Record of Meeting ACP-323296-25

Case Reference / Description	Proposed development of 11 no. turbine wind farm located in Raheenakeeran, Enaghan, Clonsast Upper, Clonsast Lower, Cushina (Ballyshear E.D), Cushina (Bracknagh E.D) and other townlands in County Offaly.		
Case Type	Pre-application consultation		
1st / 2nd / 3rd / 4th Meeting	3 rd Meeting		
Date	20 July 2026	Start Time	2:30pm
Location	MS Teams	End Time	4:05pm

Additional Haul Route Upgrade

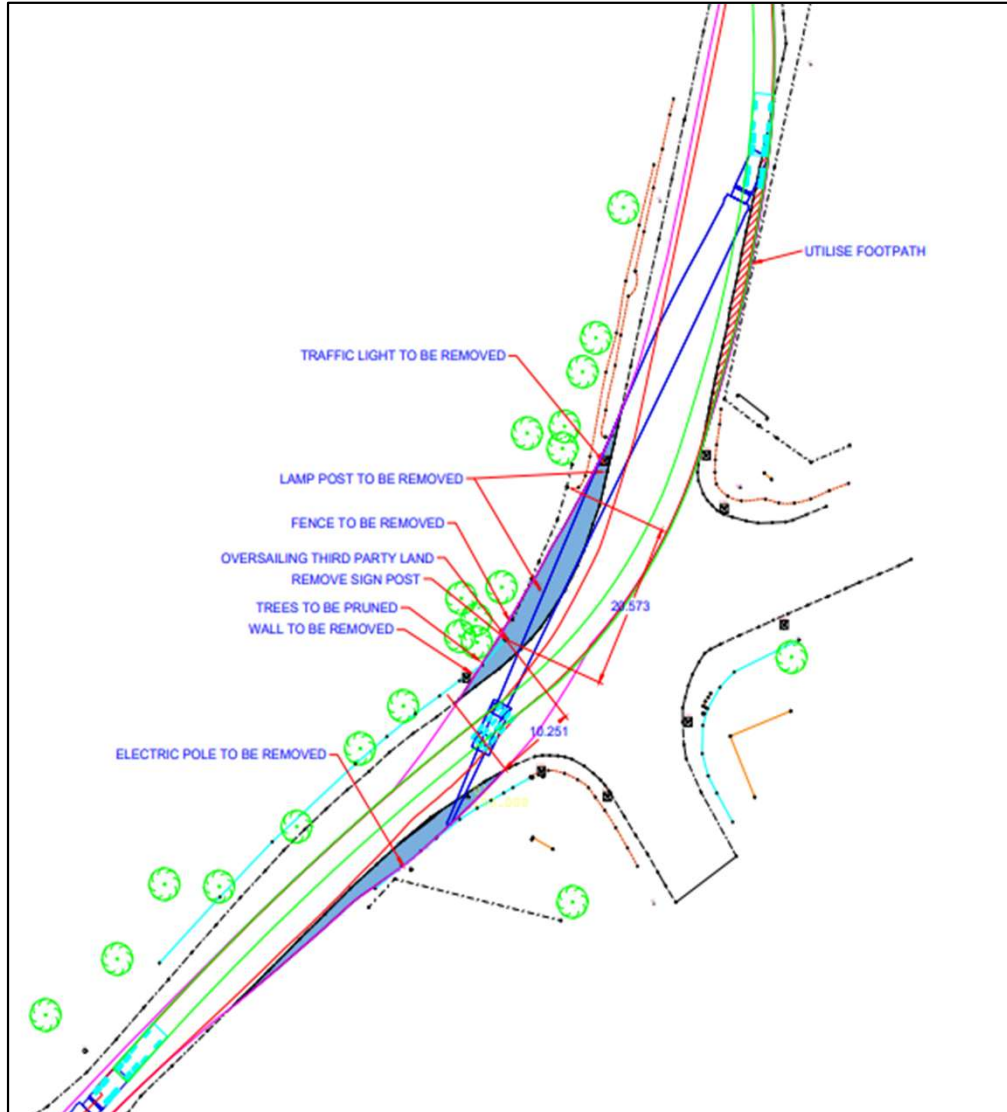
- The Commission's representatives queried whether the road junction in County Galway, where the removal of a wall and fence are required, is signalised and whether such works would require temporary removal of traffic lights. The prospective applicant advised that these traffic lights are intended to be removed and that consultation is ongoing with Galway County Council. It is intended that a meeting will be held with Galway County Council roads department prior to the application being submitted.
- The prospective applicant noted that the project's scope has not changed from previous meetings.
- The Commission's representatives queried whether it is the intention to include the grid connection as part of this application process. The prospective applicant advised that one single grid connection would be presented as part of the application and be assessed in the EIAR.

- The Commission's representatives recommended that details of the proposed works at the Galway road junction where signalisation is to be temporary removed should be assessed.

Noise & Vibration (continued)

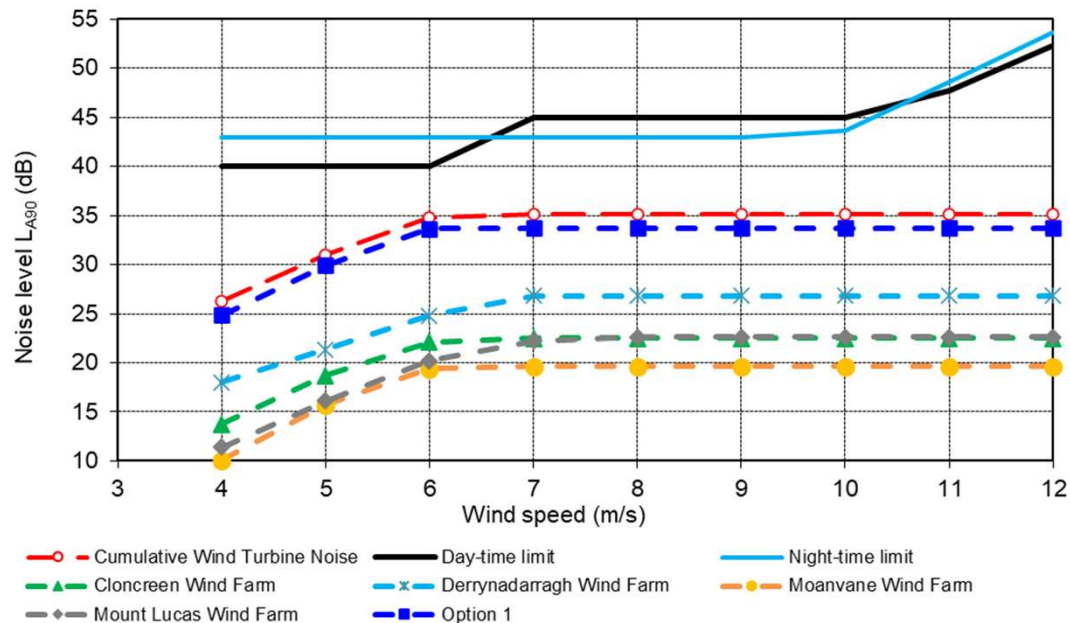
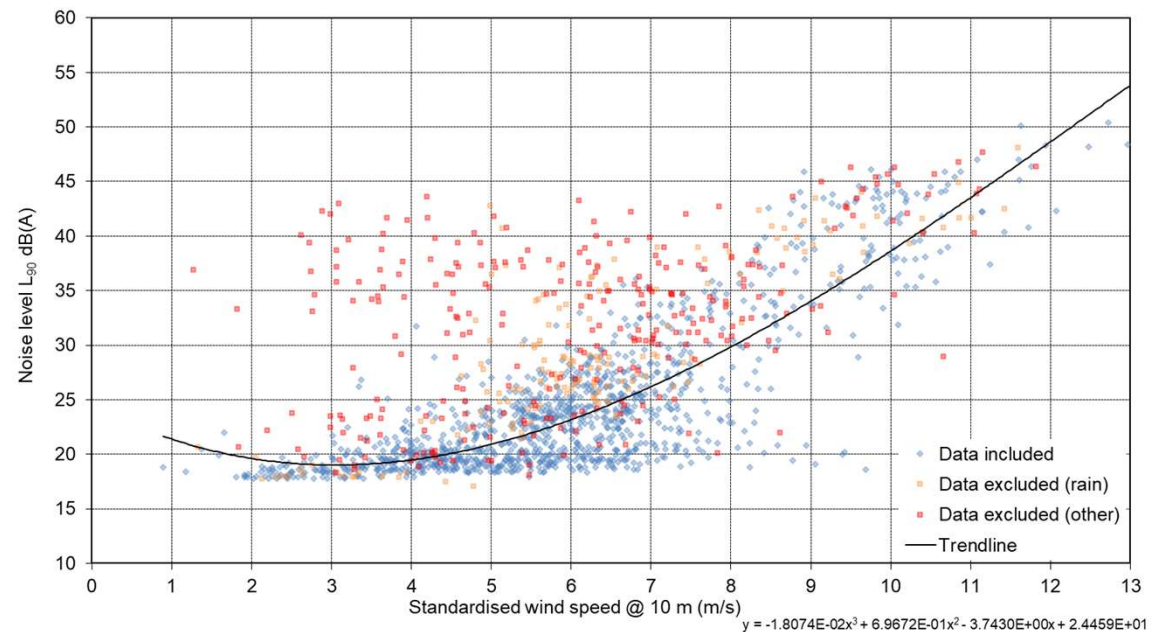
- The Commission's representatives queried the selection of noise monitoring locations, specifically to the west of the proposed wind farm and advised that a clear rationale be provided for the sites selected for background noise monitoring. Information on where the equipment was placed including photographs would be beneficial. The prospective applicant advised that the location of noise monitoring locations to the west were selected taking account of existing wind turbine noise and permission for access obtained.

- The Commission's representative queried the sound levels and recommended that the results from the range of turbine options be included in the noise chapter of the EIAR. The prospective applicant advised that these levels would depend on the wind speed.

Viewpoint Locations

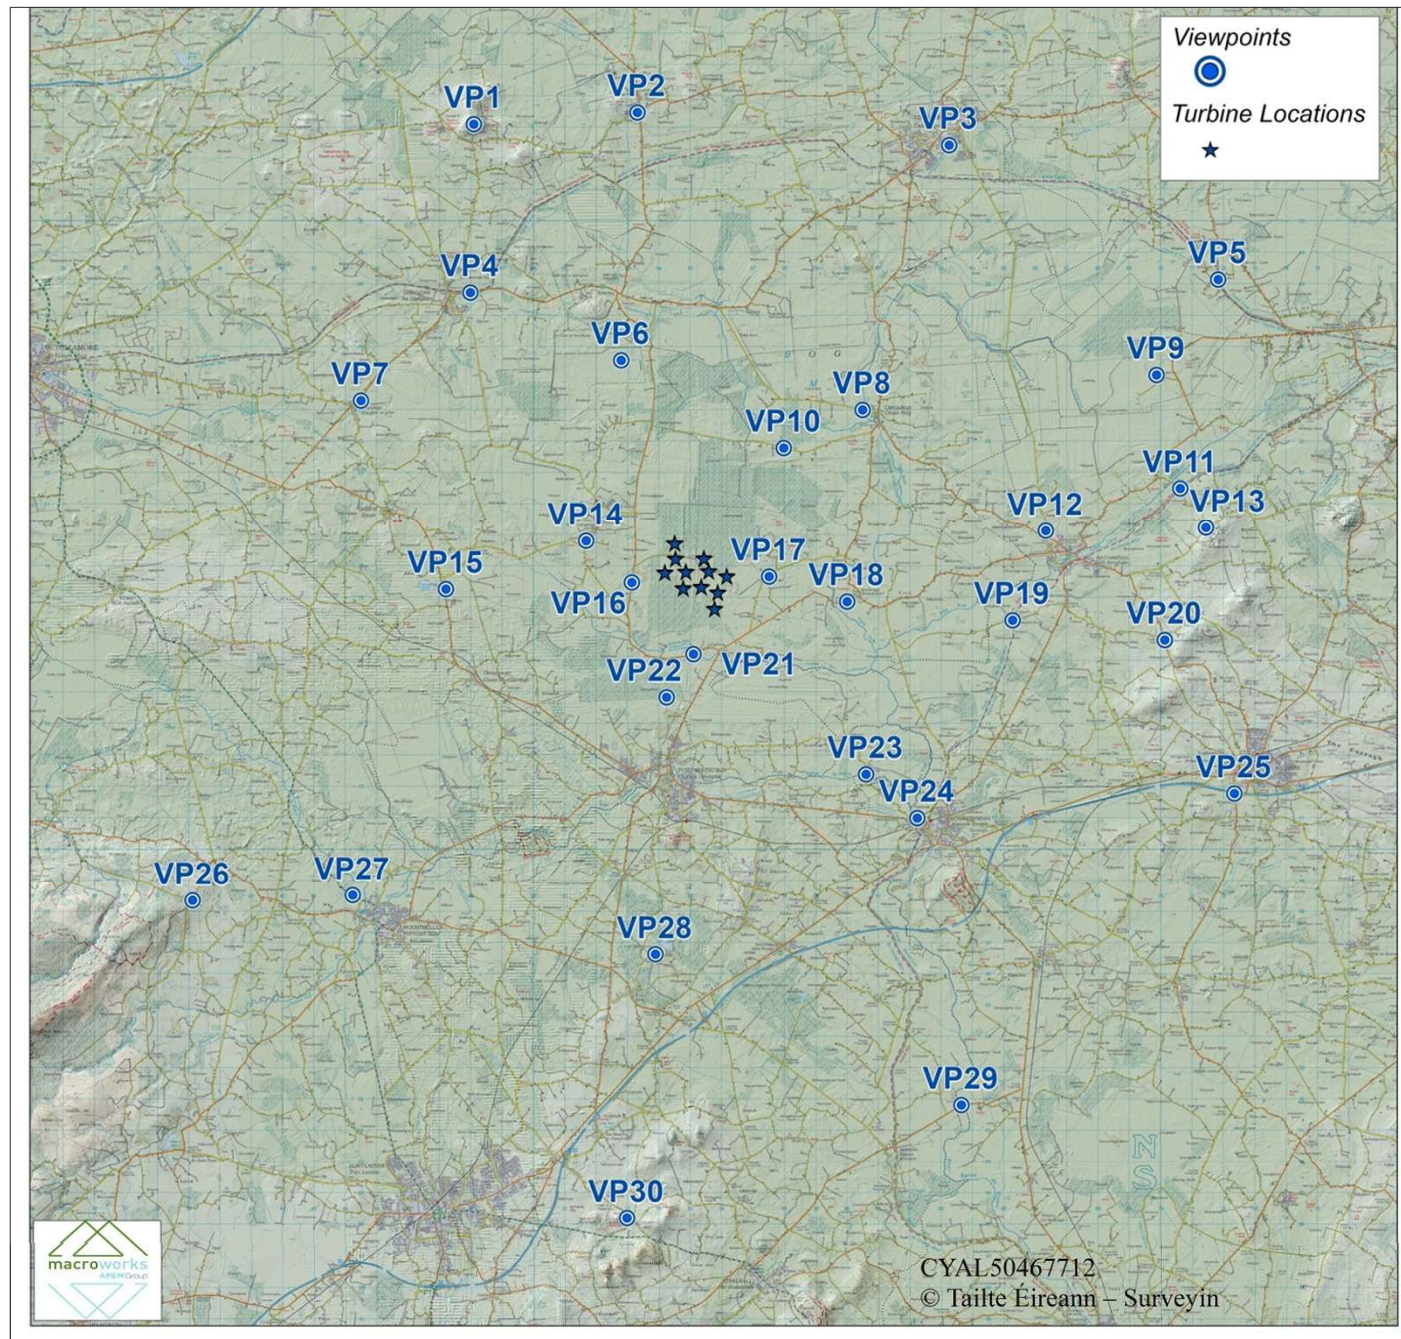
- During the presentation, photomontages were presented, and the Commission's representatives requested that a copy of these photomontages be forwarded for the file.
- The Commission's representatives queried whether the selected viewpoints had considered scenic views and scenic routes identified in the respective county development plans, and that a clear rationale for viewpoints be provided. The prospective applicant confirmed that this was the case.
- The Commission's representatives noted the location of Slieve Bloom Mountains outside the 20km LVIA study area, and advised that a clear rationale for the study area to be provided.
- The Commission's representatives noted the importance of clarity in the landscape and visual assessment methodology, specifically in relation to the findings of no significant effects, and in the application of any mitigation measures.
